PORTLAND MAINE

January 8, 2010

Re: 12 Tarbell Street – 332 E038 – R-3 – 16' x 20' single story addition – permit #09-1235

<b>PLOT PLAN</b>	
SCALE: 1/4" = 1'	APPROVED BY:
DATE: OCT 29 09	DRAWN BY: JUDY ALLEN/AS
BEDROOM ADDITION 16X20	
OWNER: GREGORY GAY 12 TARBELL ST	
PARL AND 318	
DRAWING NUMBER	I

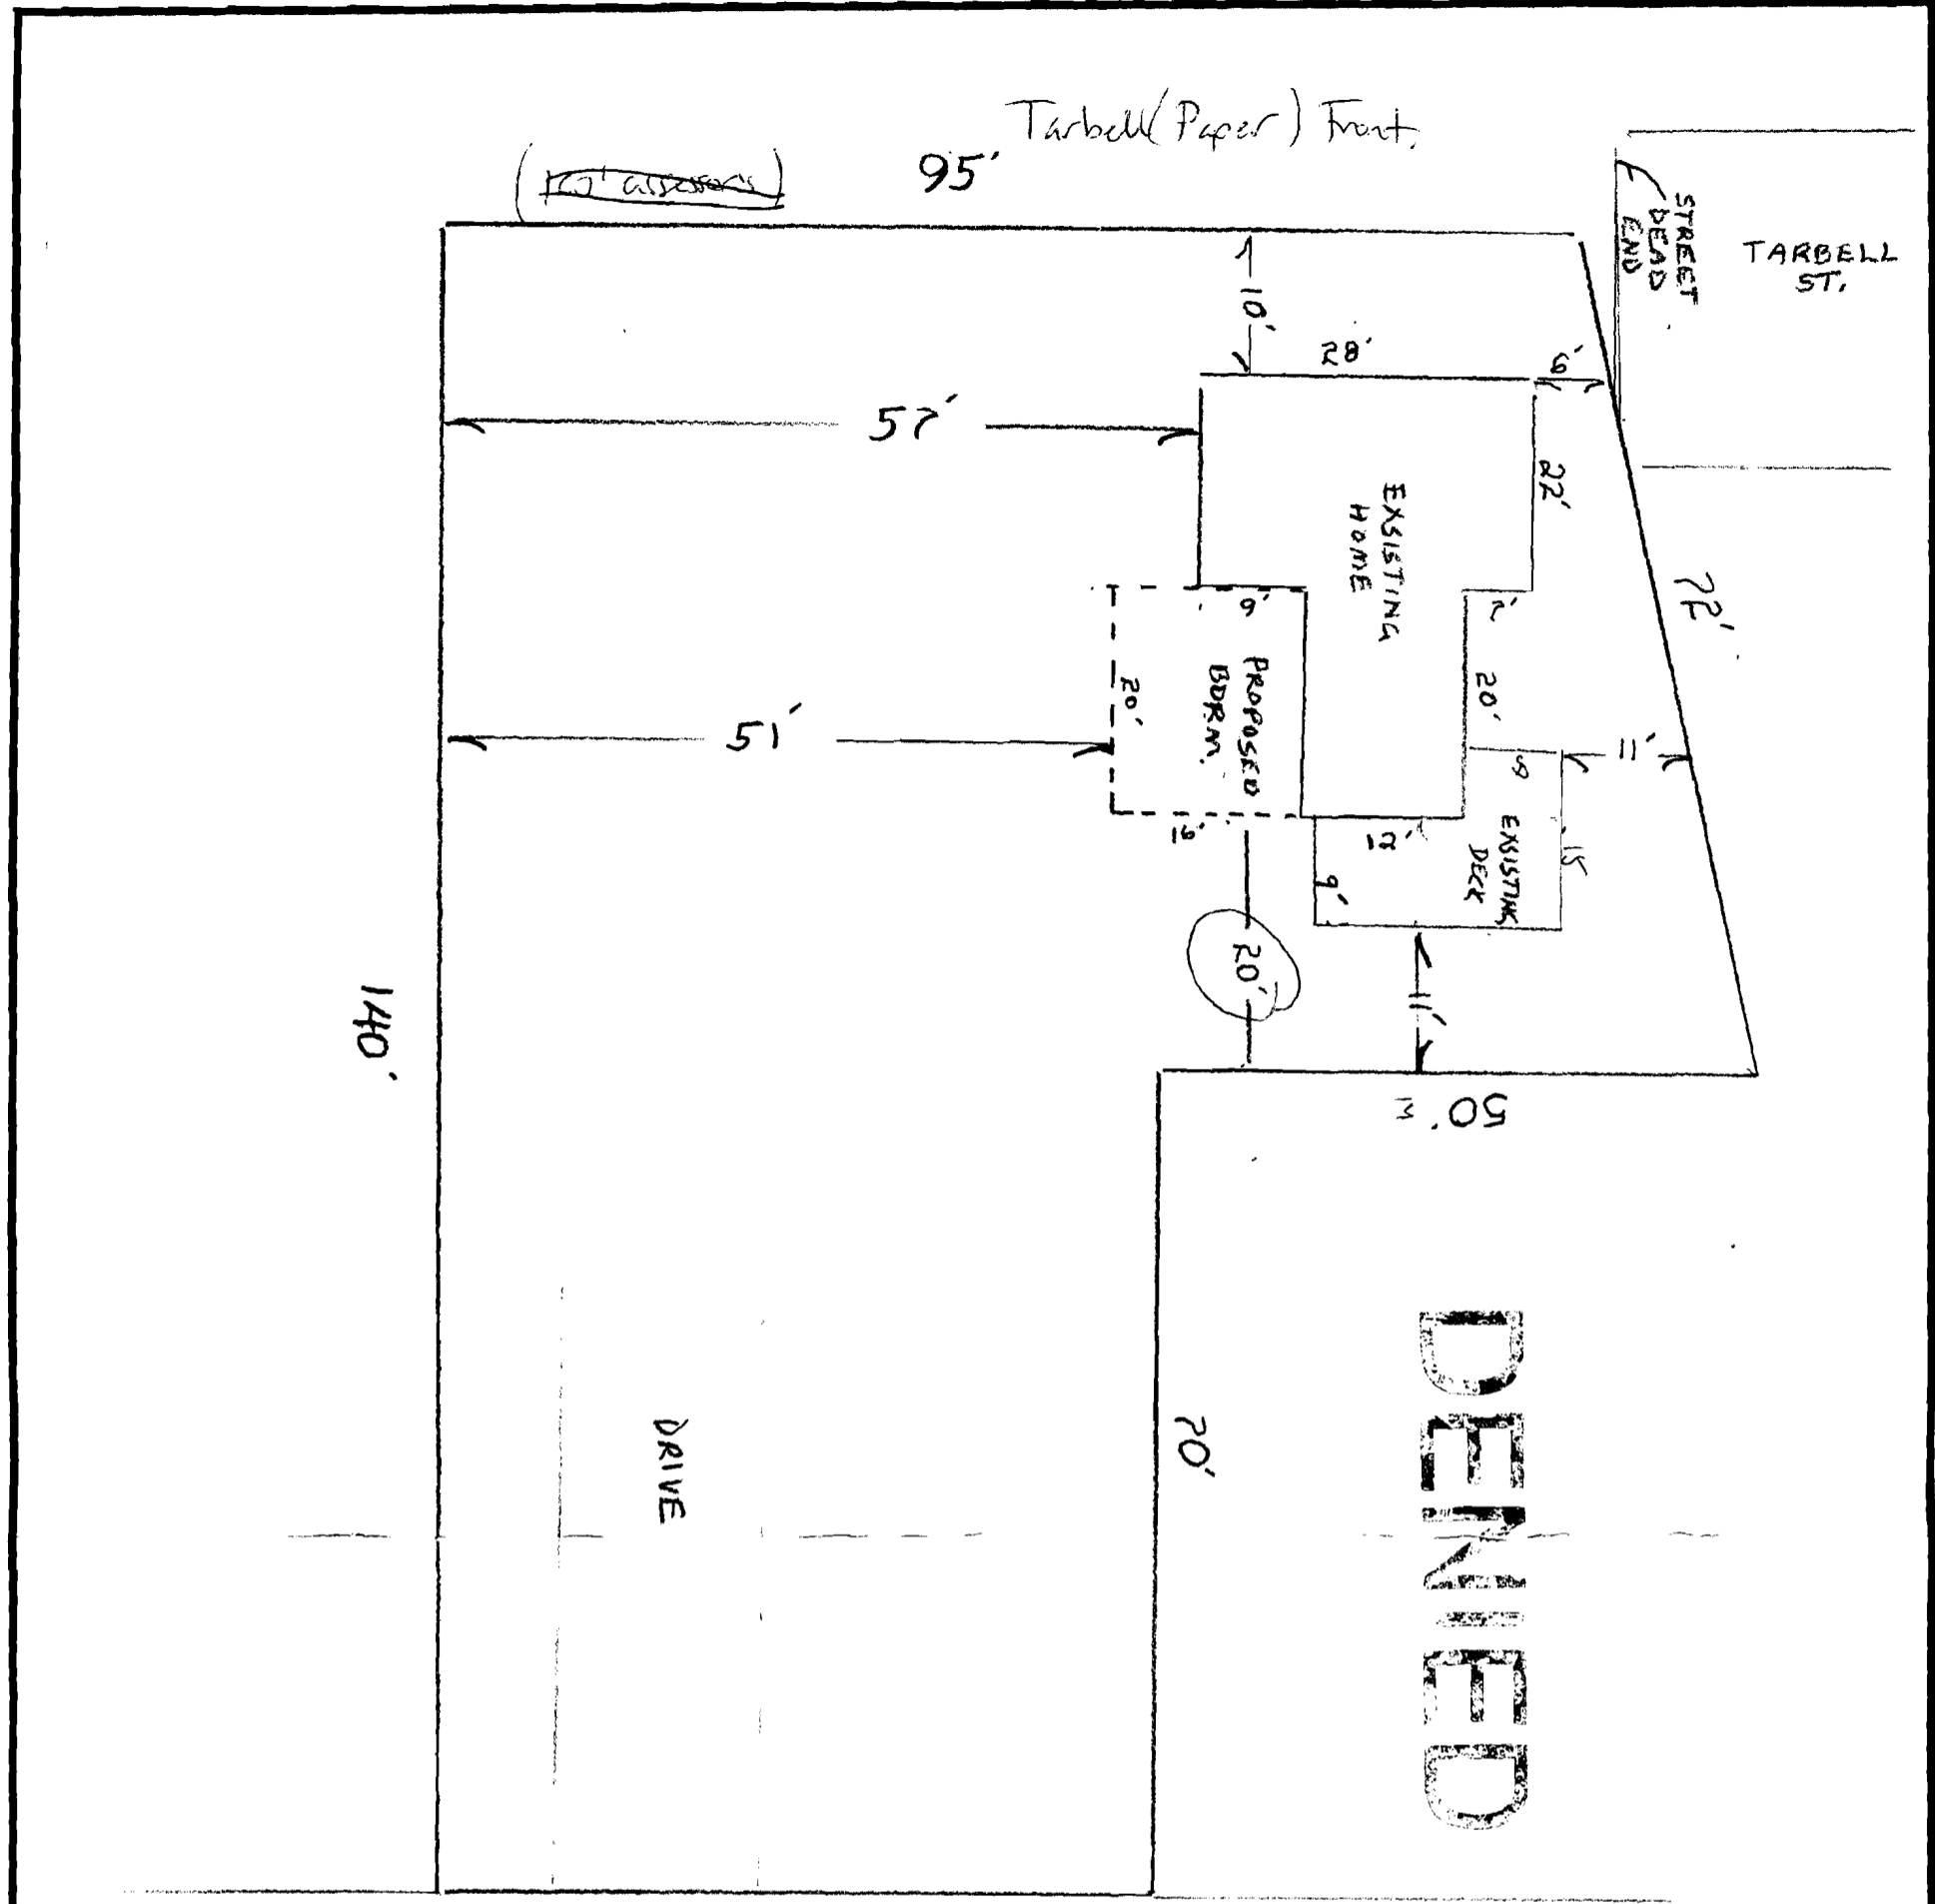
12 Tarbell Street is located in the R-3 residential zone. The required rear setback in the zone is twenty-five feet [Section 14-90(d)(2)]. The plot plan shows the rear setback to the proposed addition as twenty feet. Since it does not meet the required setback, the permit is denied.

In reviewing the permit application, it came to my attention that the existing deck on the rear of the house has never been permitted. We have no record in our system for a deck having been built. When we cannot find a permit for a structure, we default to the pre-1957 assessor's record. The pre-1957 assessor's record shows a six by twenty foot deck on the left rear side, but not the deck that exists now. Since the existing deck was not built before 1957 and there is no record of it being permitted, it is illegal.

The property must be brought into compliance. Since the setback for the existing deck does not meet the required twenty-five foot rear setback, it cannot be permitted after the fact. Since it cannot be permitted, it must be removed. You have thirty days from the date of this letter to remove the deck.
